## Conversation with Deb Andrews, 3/20/2018, re. 415 Cumberland Avenue

EXISTING WINDOWS TO BE REFURBISHED WHERE POSSIBLE, AND WHERE NECESSARY TO BE REPLACED WITH NEW WINDOWS TO MATCH EXISTING (NEW WINDOWS WILL BE DOUBLE GLAZED BUT WILL MATCH IN APPEARANCE)

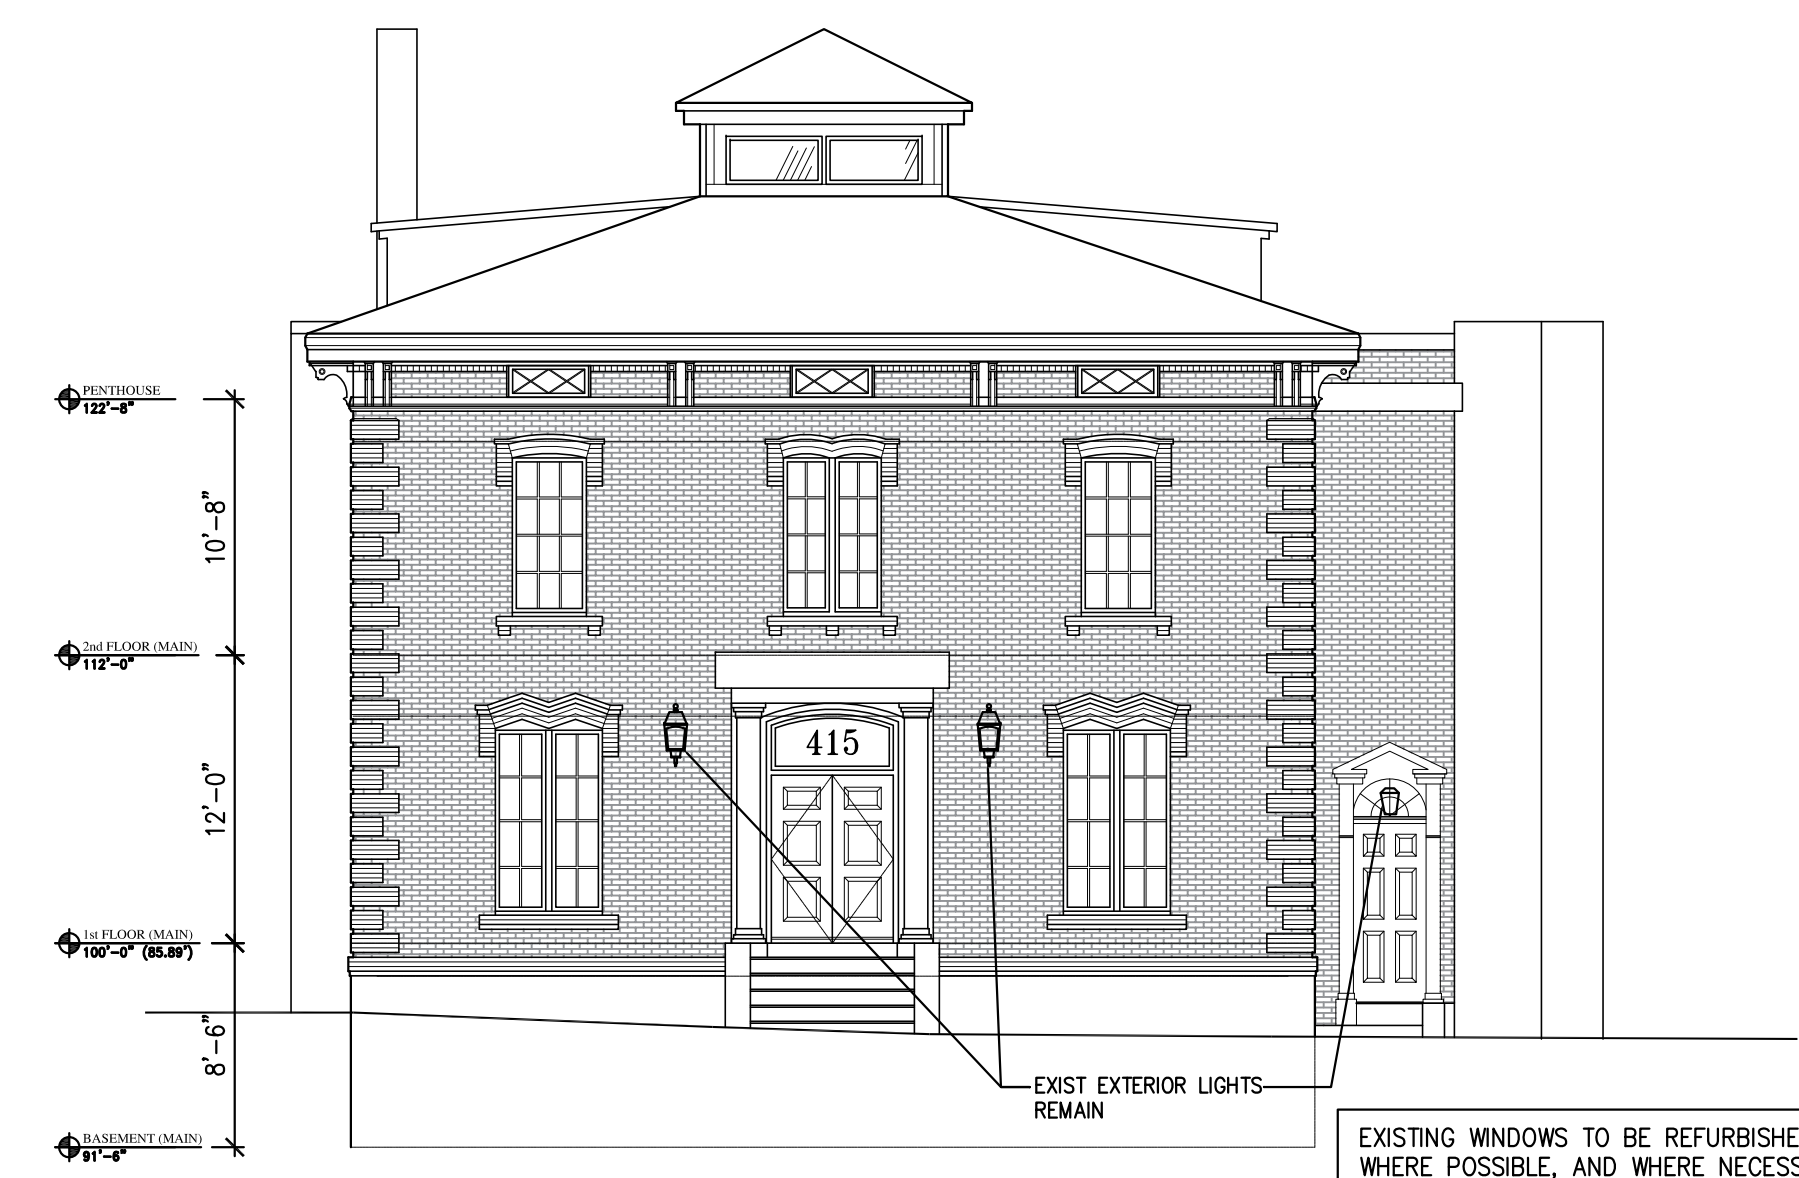
Request details on new windows. What are the materials? Windows should feature simulated divided lites with applied exterior muntins, at a minimum. Also, which windows will be repaired/replaced?

Request details regarding window moldings: will brick moldings be replicated in aluminum trim on other, new windows?

Why are two windows on the northwest elevation not the same height as all other windows on the northwest elevation and Forest Avenue elevation? Ideally these will match.

Request details regarding finishes. Painted finish of Hardie plank should not be high contrast, nor should relationship of trim to body of building be high contrast.

What is reveal / ttw of Hardie plank? (Reveal should be less than 6.”)

Hardie plank should be installed smooth side out (please note on plans).

Exhaust vents should be painted to match surrounding material (brick or Hardie plank siding).

Hardie plank at top of building parapets on Forest Avenue and southwest elevations seem strange – the treatments / bands along the top of the building’s middle section should be continued.

Will garage doors be replaced? If so, materials / details requested.

Request details regarding proposed new door on Forest Avenue, especially regarding material and panelization.

Coal chute should be retained, not removed or covered.
